CITY OF ALBUQUERQUE

March 8, 2024

RE: 8701 Glendale Ave. NE
Grading & Drainage Plan
Engineer's Stamp Date: 02/06/24
Hydrology File: B20D069

Based upon the information provided in your submittal received 02/28/2024, the Grading & Drainage Plan **is not** approved for Grading Permit. The following comments need to be addressed for approval of the above referenced project:

C1

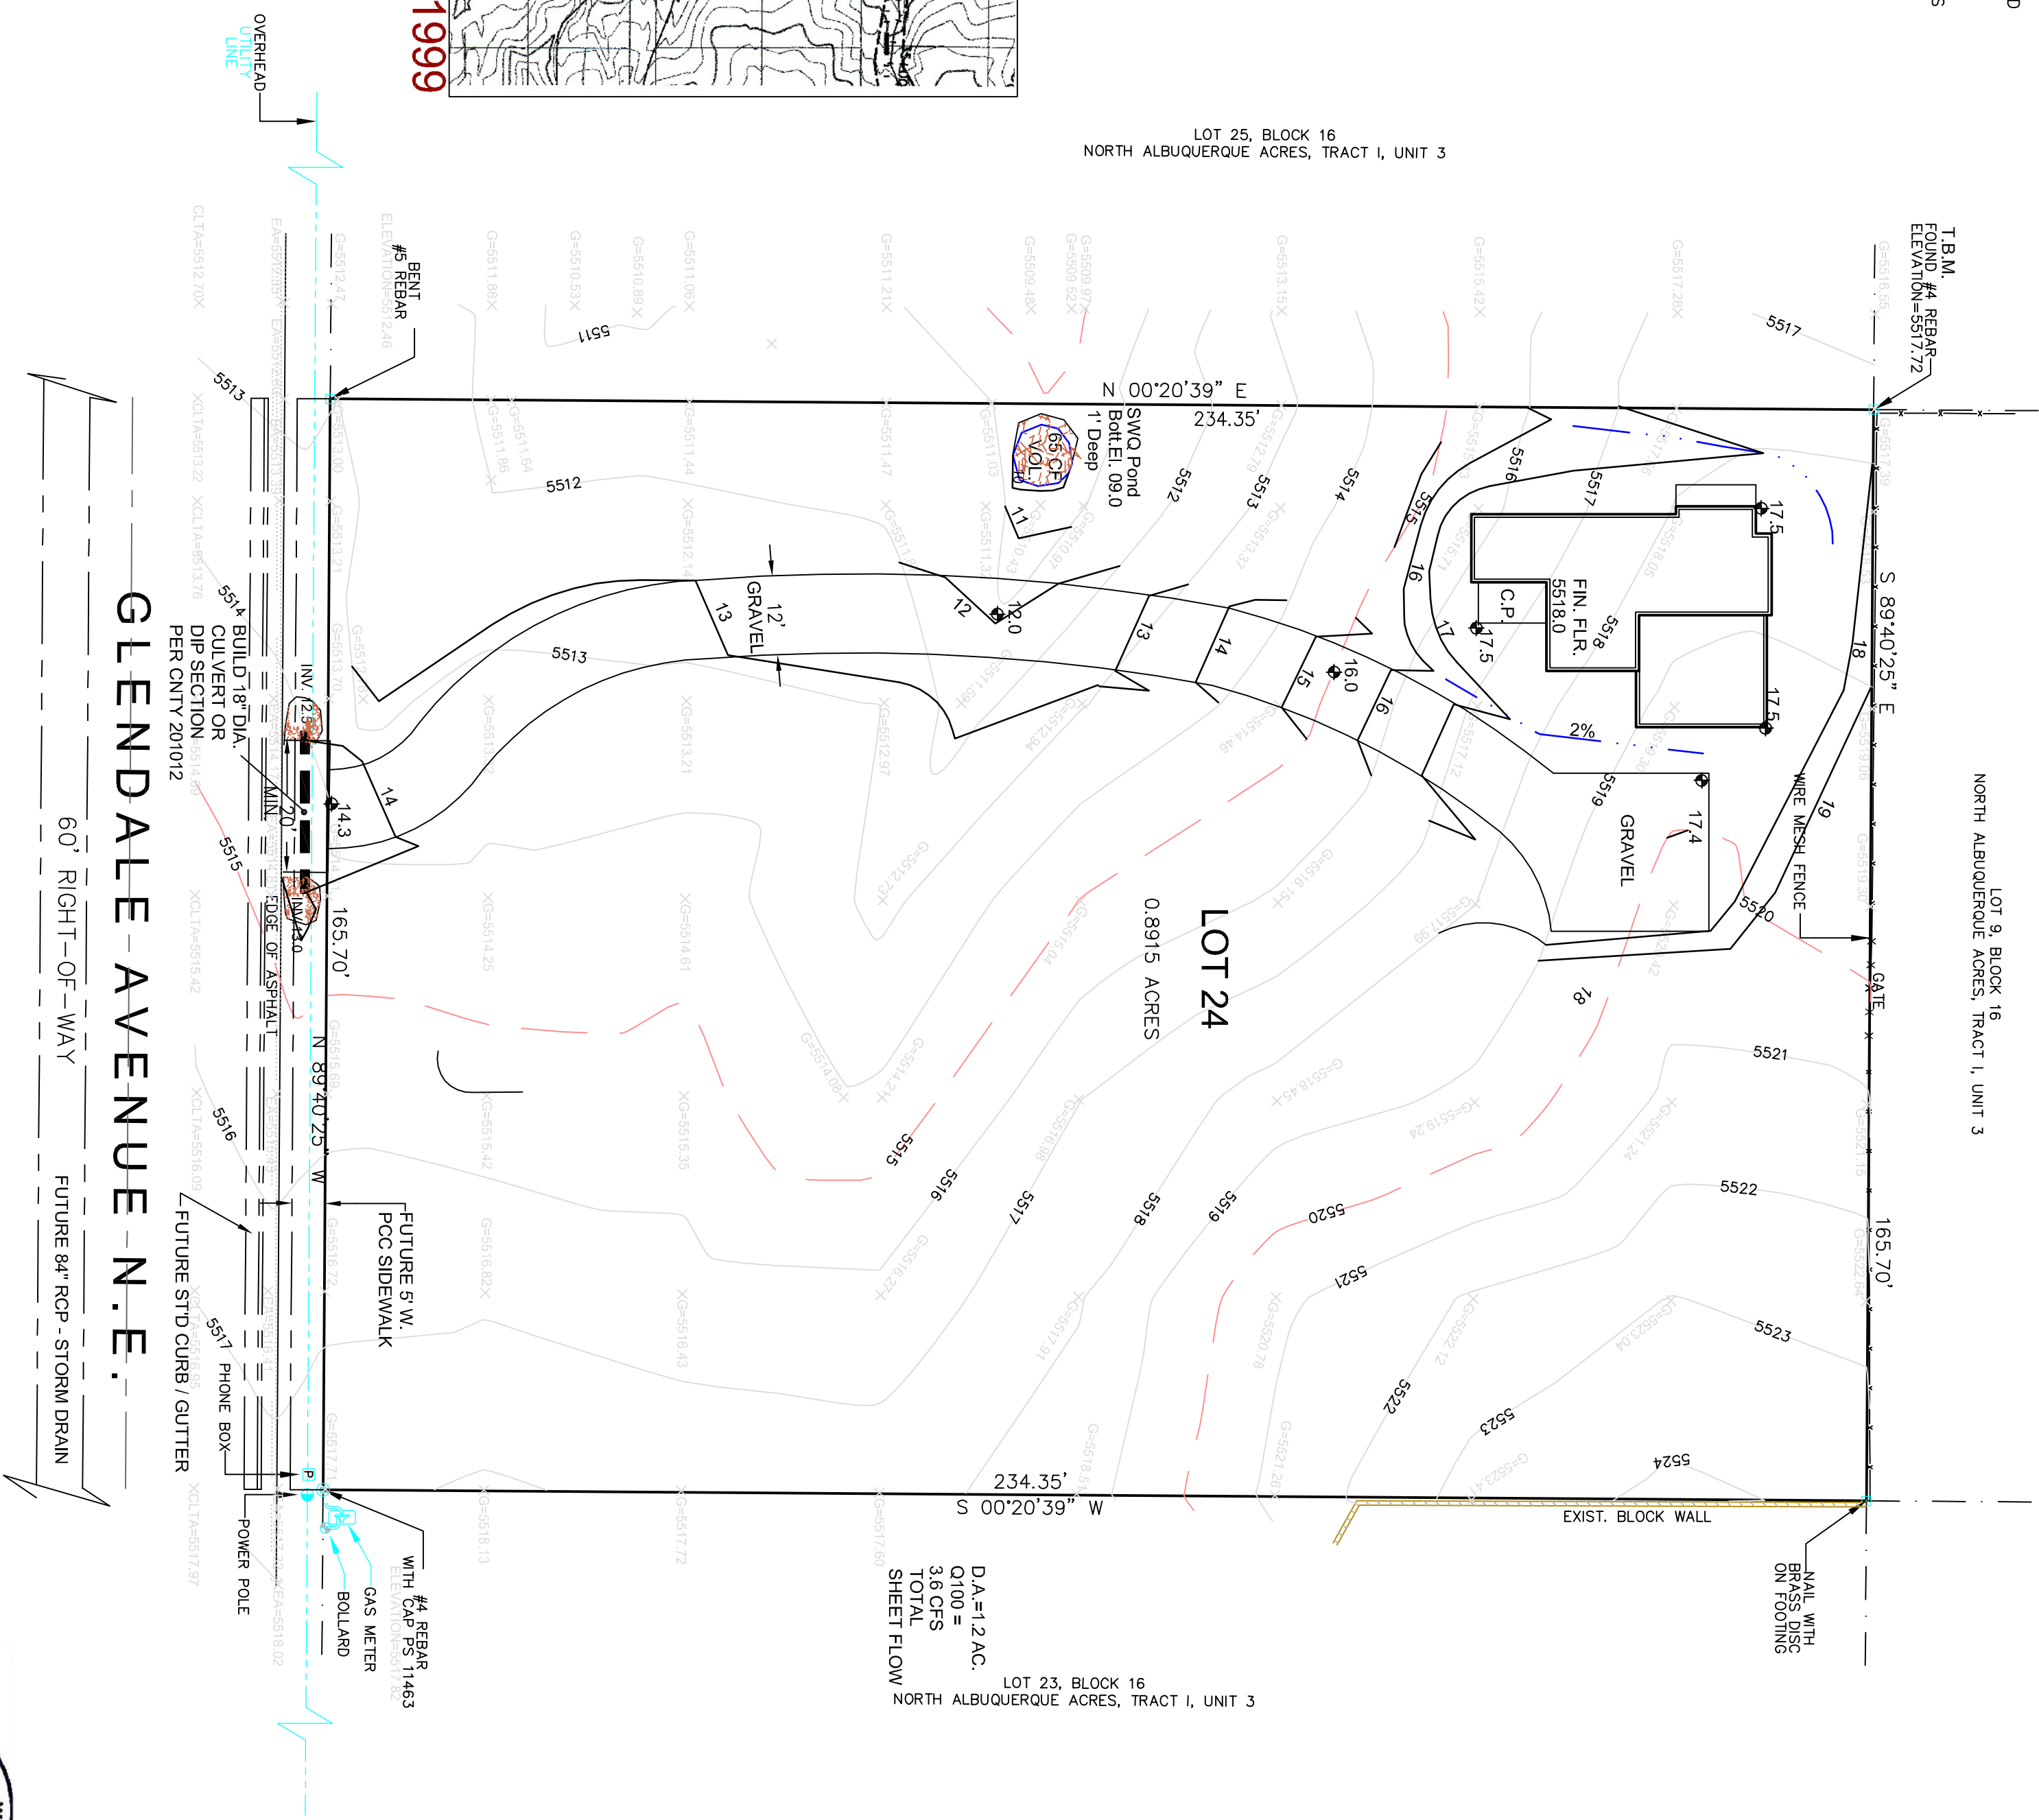
1. Per the IDO, the property owner of the property is responsible for building the adjacent half of Glendale Ave. NE to include curb & gutter, and sidewalk. The project will have to go to the Development Facilitation Team (DFT) for approval of the Infrastructure List. Also, half of an 84" storm sewer (see below) will also need to be added to the Infrastructure List. The storm sewer was called out in the NAA MDP.

2. These improvements will need to be shown on the Grading & Drainage Plan.
3. Please check to make sure that this property doesn't need to be replated as well with the Development Hearing Officer (DHO).

4. Properly showing and calculating the existing drainage that goes in the natural arroyo and Glendale from the east to the west needs to be done. This existing drainage needs to be allowed to go through the property and can be managed somehow in the proposed development.
